SSD 6471 SYDNEY MODERN, AGNSW EXPANSION PROJECT - RESPONSE TO SUBMISSIONS ADDENDUM REPORT, EXCL MARITIME ARCHAEOLOGY.

Thank you for the invitation received 10 August 2018 to respond to the Art Gallery of NSW's (AGNSW) Response to Submissions Addendum 1 Report dated 8 August 2018. The following documents were reviewed.

Attachment: Heritage Council comments on Addendum 1 modifications.

23 August 2018

PLAN SHOWING PROPOSED SUBDIVISION OF LOT 34 IN D.P.39586
AND LOT 4 IN D.P.259027
IN SYDNEY L.G.A.

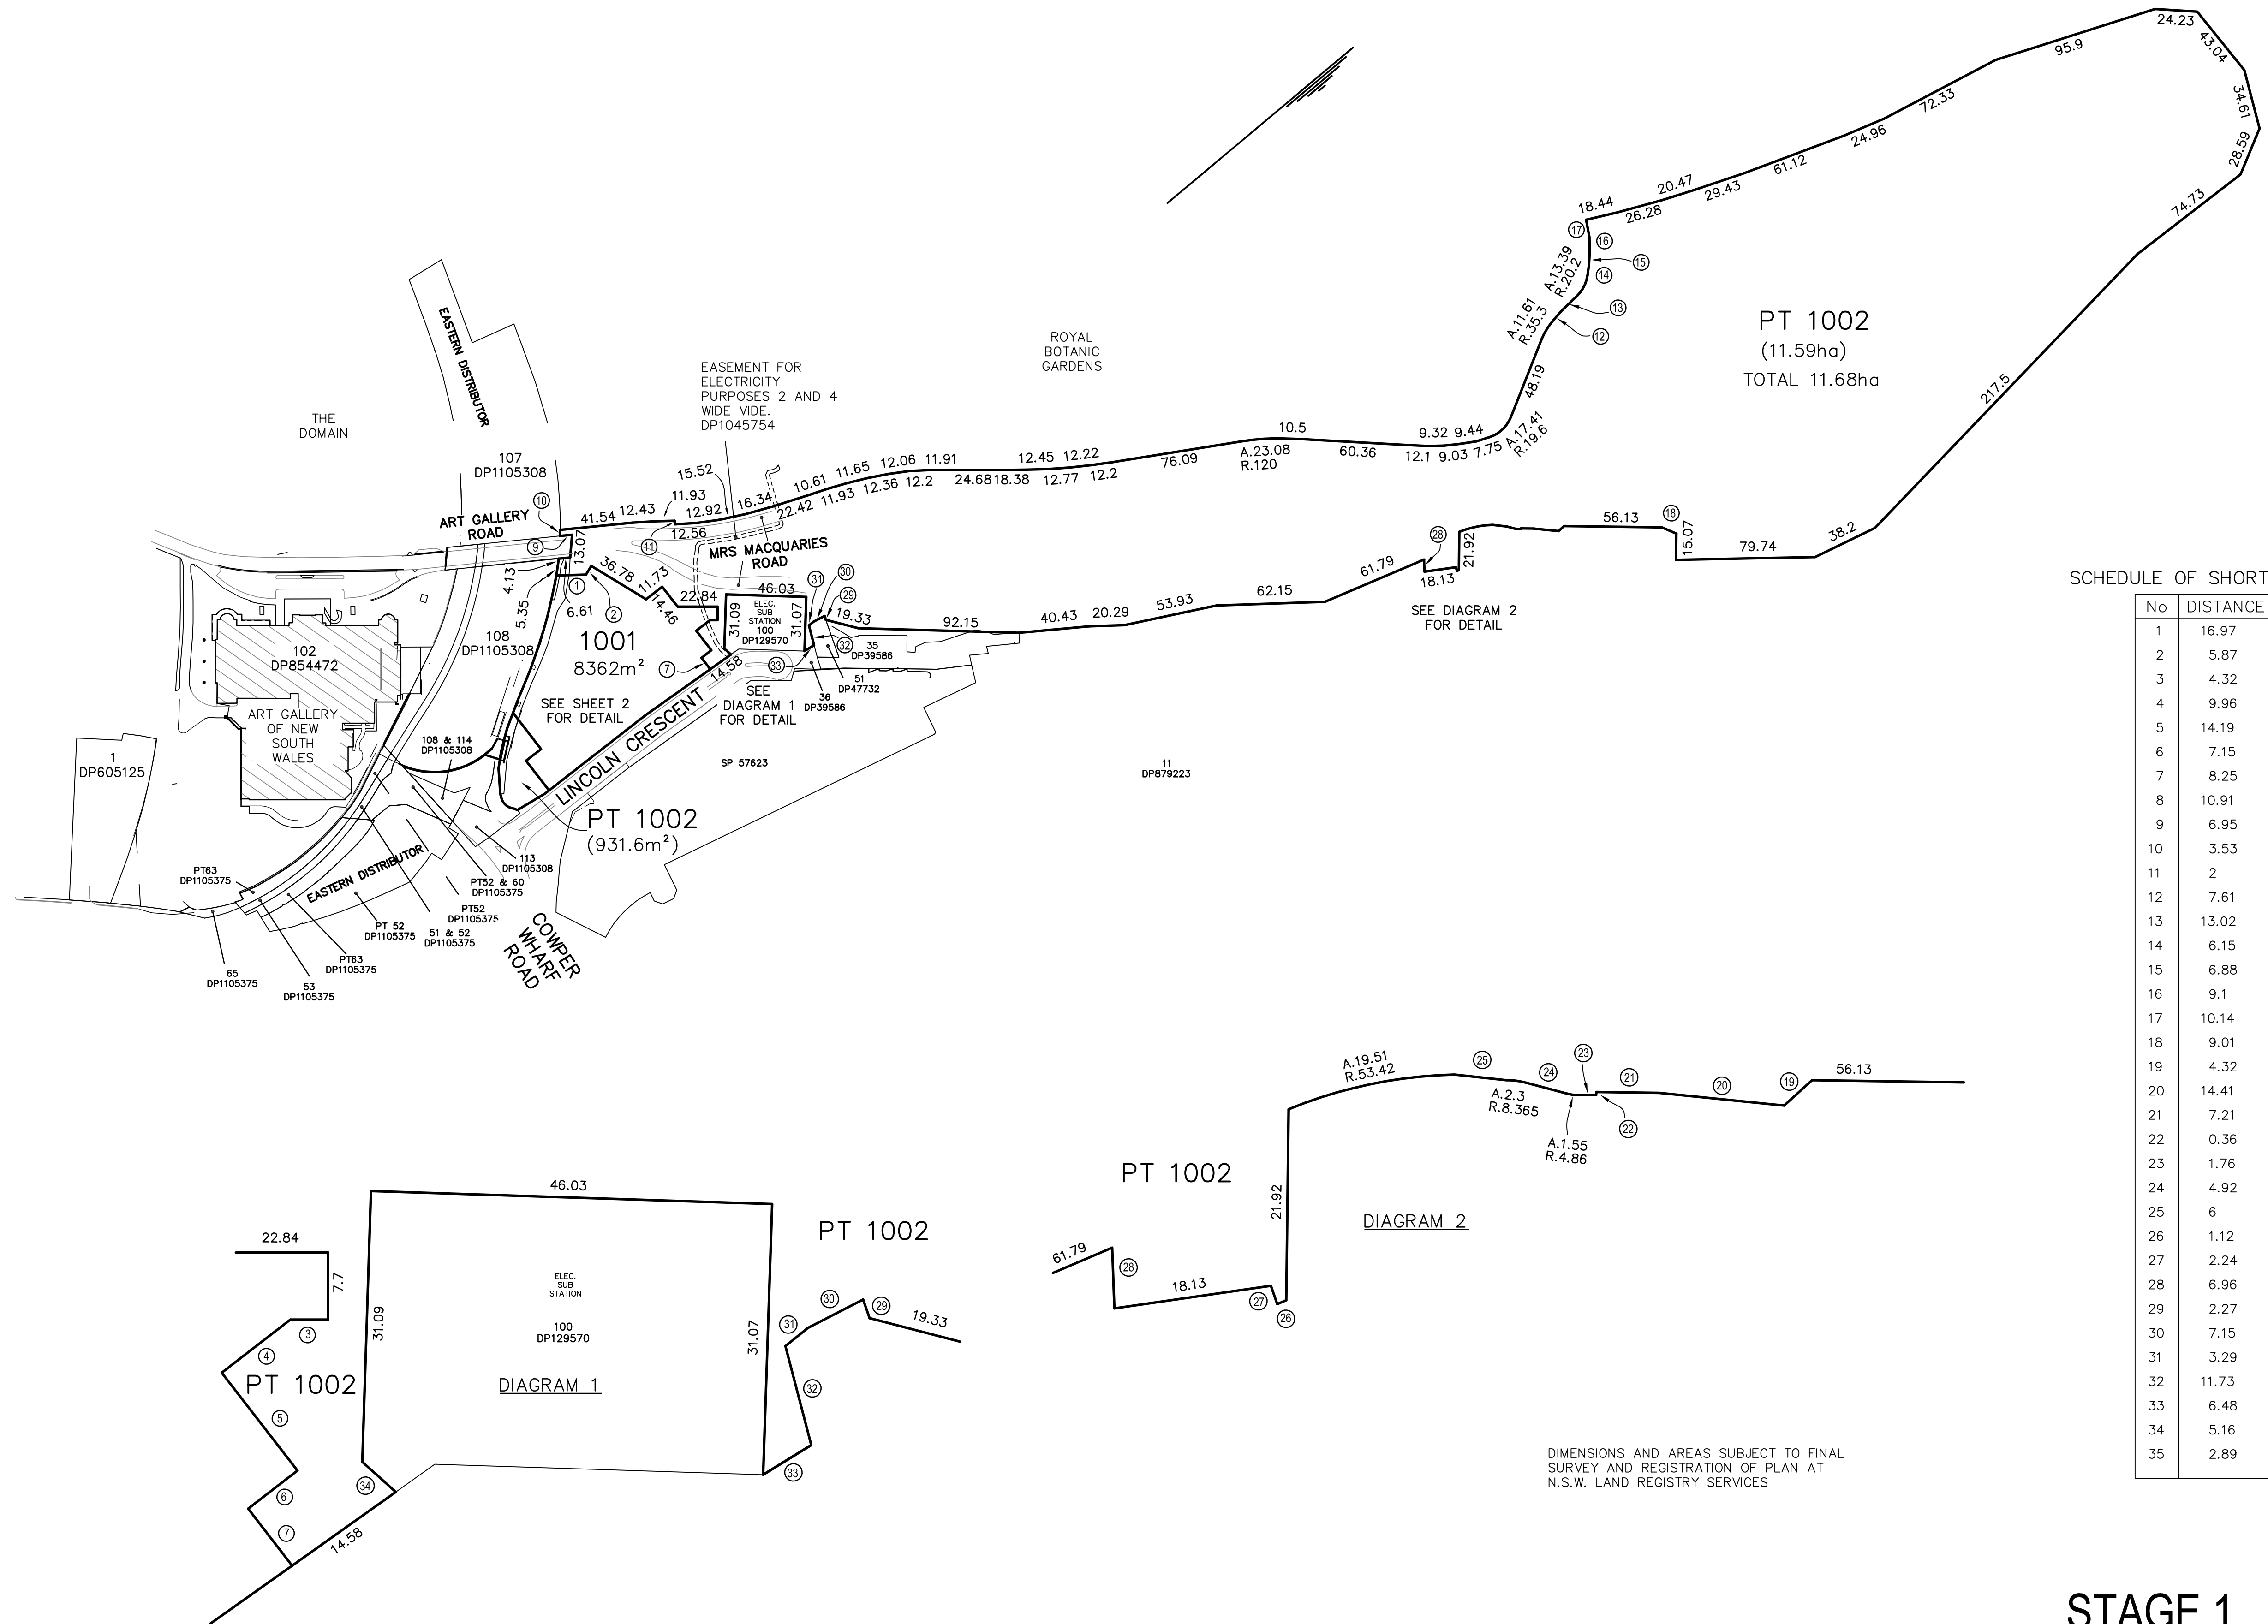
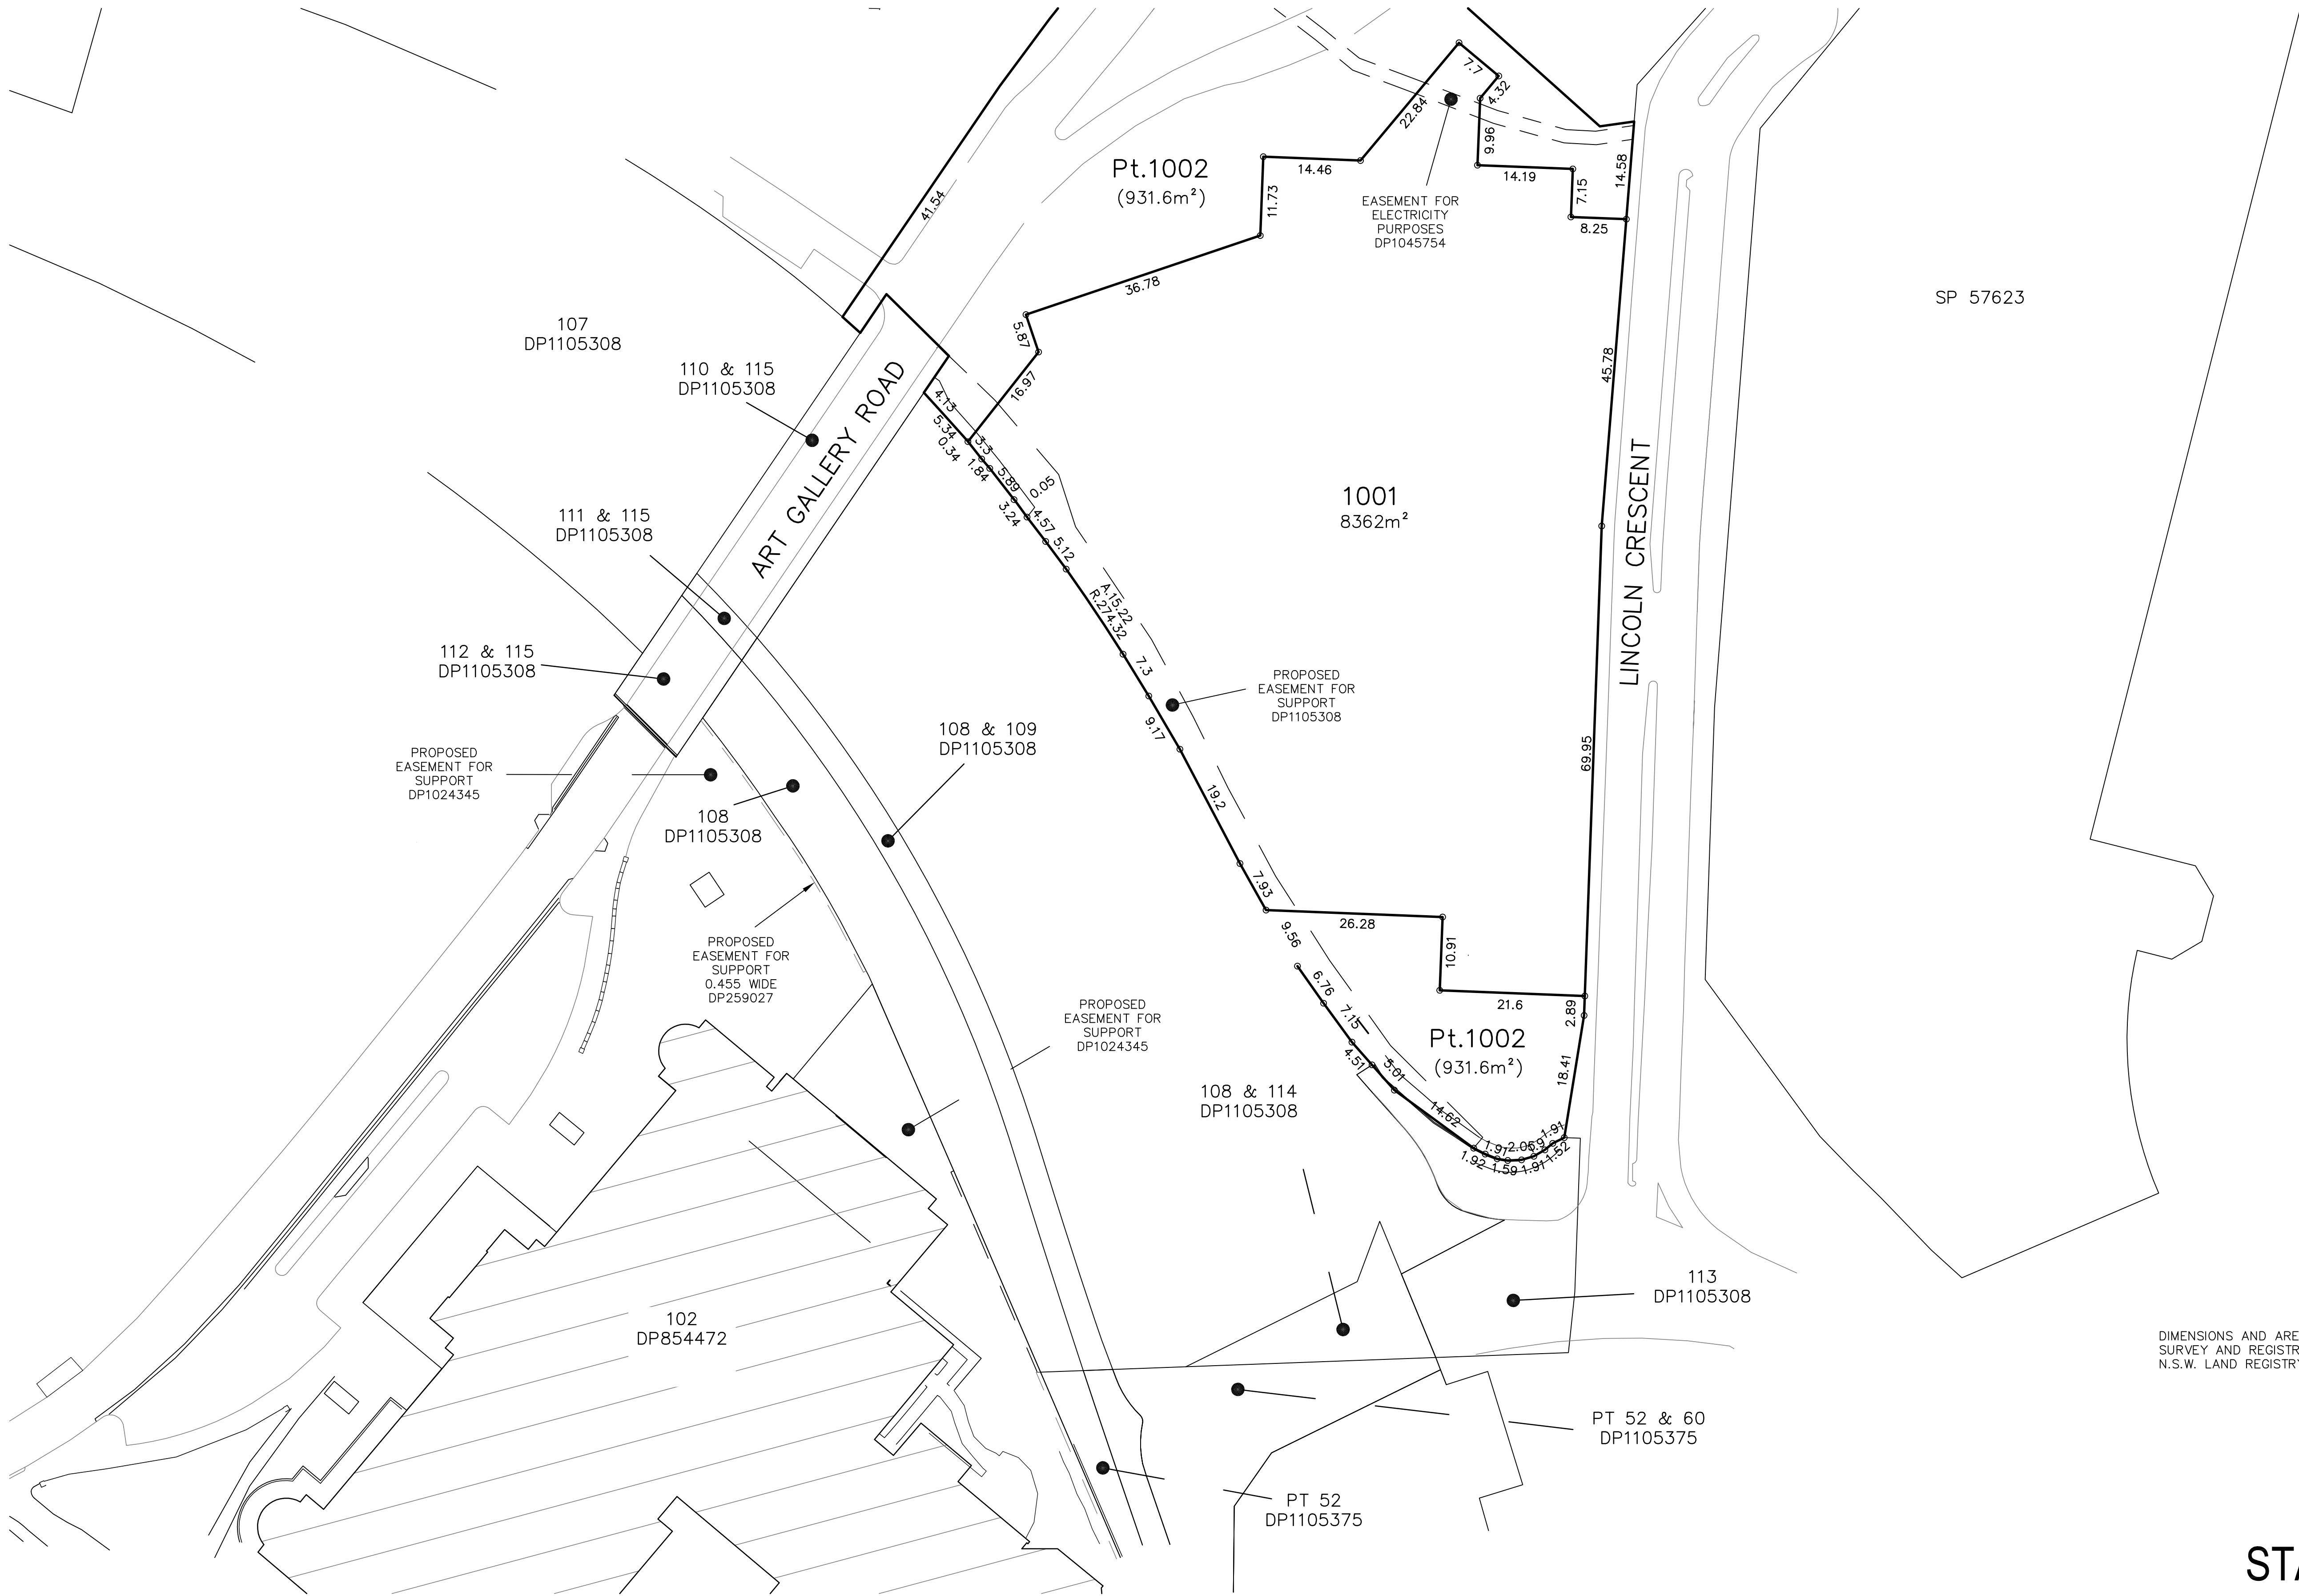
7	Subdivision	<p>It is noted that subdivision plans were not submitted and assessed with the Environmental Impact Statement. However, subdivision plans were submitted with this addendum.</p> <p>The subdivision affects the Sydney Modern AGNSW expansion site only. The subdivision formalises land ownership and use between the Royal Botanic Gardens and Domain and the land acquired for the Art Gallery expansion. The current subdivision of the Royal Botanic Gardens and Domain, in two main lots with subsidiary lots, does not have any historic value, but is the result of development in and around the park, particularly the advent of the Domain tunnel. With this, the proposed creation of new lots for the new Art Gallery extension and landscape will not adversely affect the Royal Botanic Gardens and Domain greater than the development itself.</p>
